**KIRKLEES METROPOLITAN COUNCIL
INVESTMENT & REGENERATION SERVICE**

Reference No: 2020/62/92208/E

Site Address: 1A, Water Royd Avenue, Mirfield, WF14 9LR

Description: 'Erection of single storey front, side and rear extensions with outbuilding and associated works

PROPOSED BLOCK PLAN
1:200

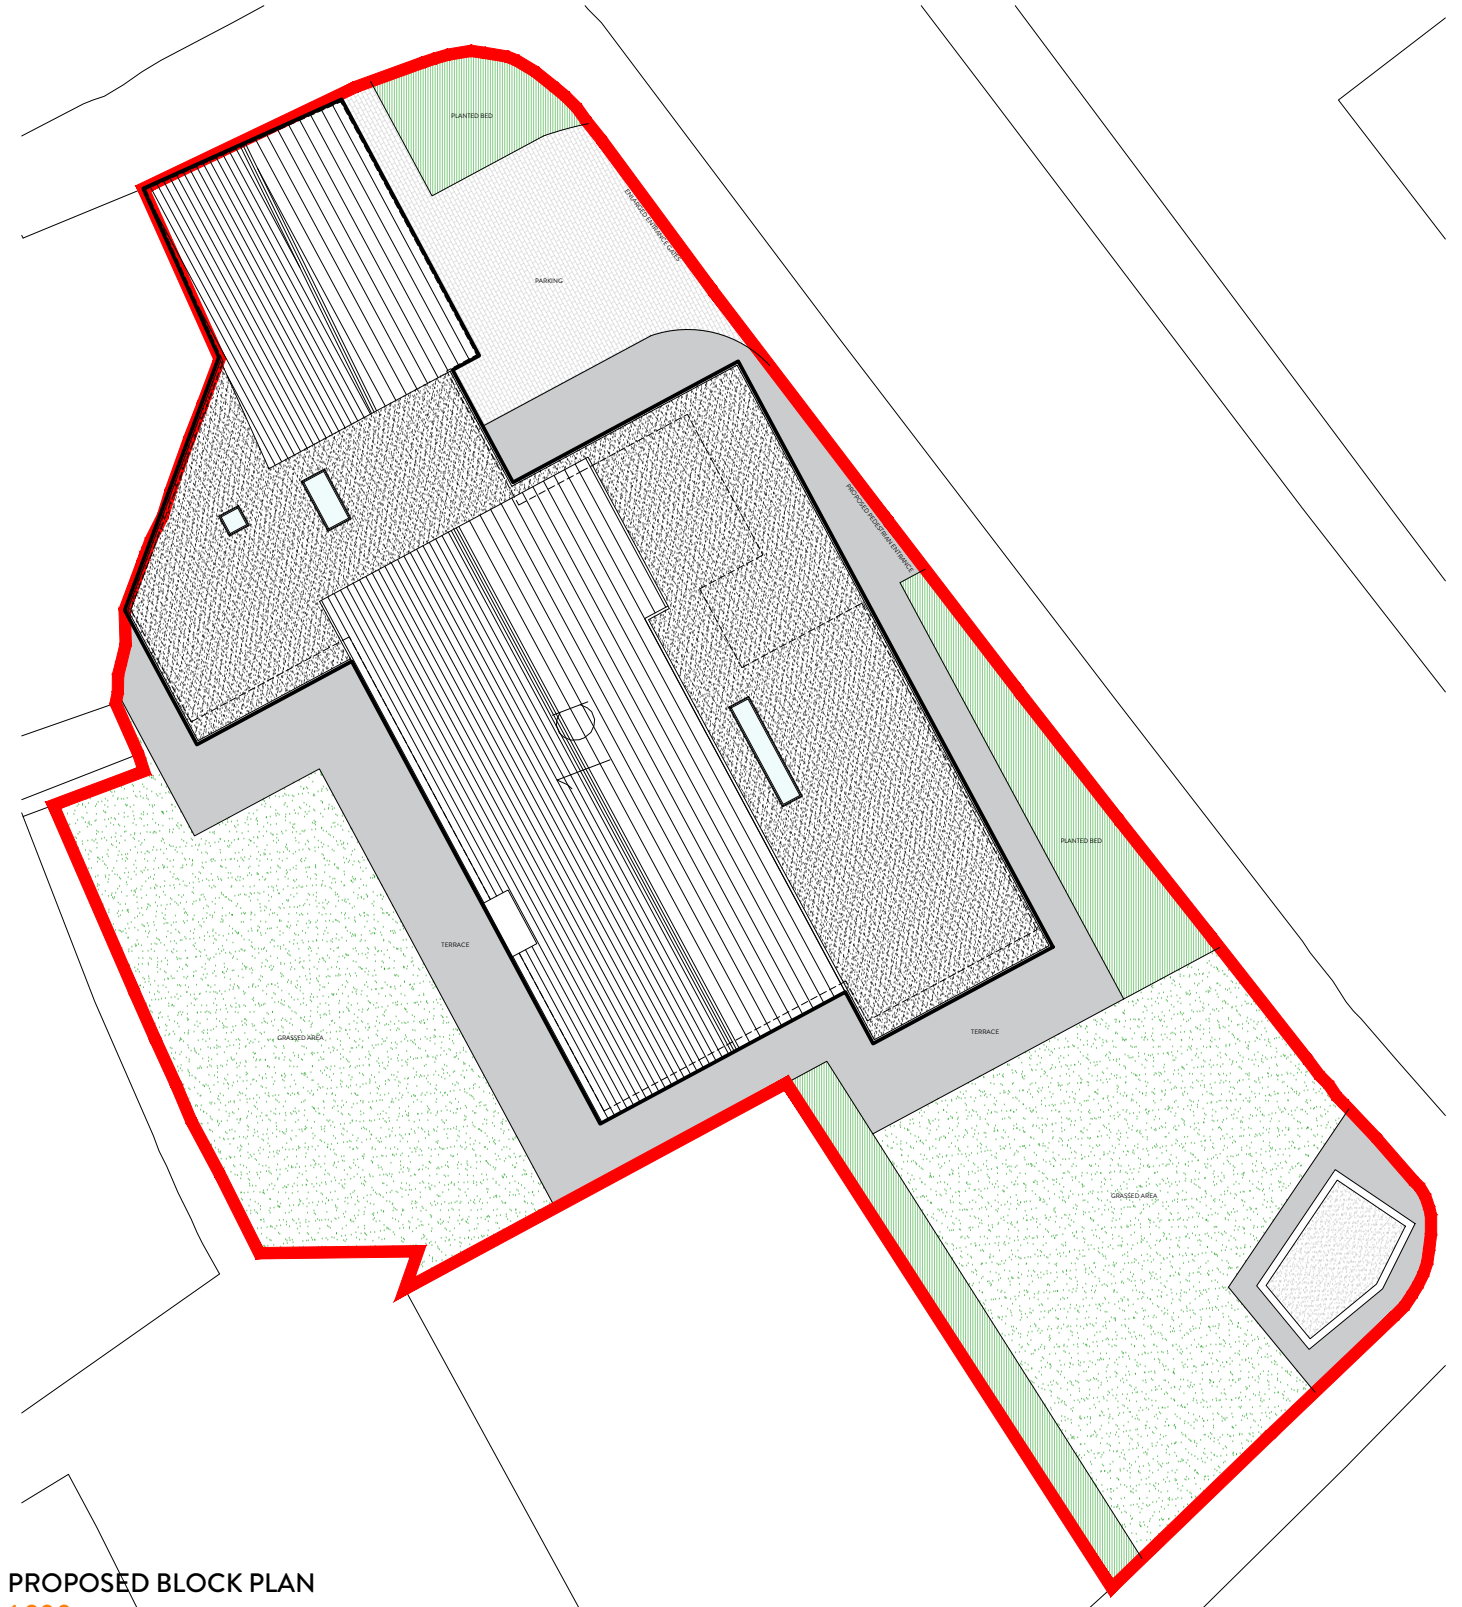
All houses on the same road have a spacious garden to the front. This is considered an integral element of the local character. The development proposal, if permitted, would replace the existing front garden with a large unsympathetically designed flat roof extension and an irregular-shaped timber clad outbuilding. This would significantly prejudice the visual appearance of the bungalow and detract from the character of its immediate surroundings. There would also be substantial harm caused to the local street-scenes. Consideration has been given the planning history of the site and its surroundings, but there is no site-specific circumstance that could outweigh the harm arising from the poor design of the current scheme.

The application site consists of a silver birch tree at the southern corner, protected by a Tree Preservation Order. This application seeks permission to erect an outbuilding close to the protected silver birch tree, without providing enough information to demonstrate that the outbuilding concerned would not prejudice the long-term viability of the tree. Consequently, the proposed development would not be acceptable in respect of policies LP24(i) and LP33 of the KLP in terms of retention of valuable or important trees.

2. The proposed outbuilding, in terms of its siting, would have the potential of prejudicing the long-term viability of an existing protected silver birch tree on site. There is no information submitted to demonstrate that the outbuilding could be erected without causing damage to the root and crown spread of the tree. To permit the development in its current form would not therefore conform to Policies LP24(i) and LP33 of the Kirklees Local Plan, which requires the retention of all valuable or important trees.
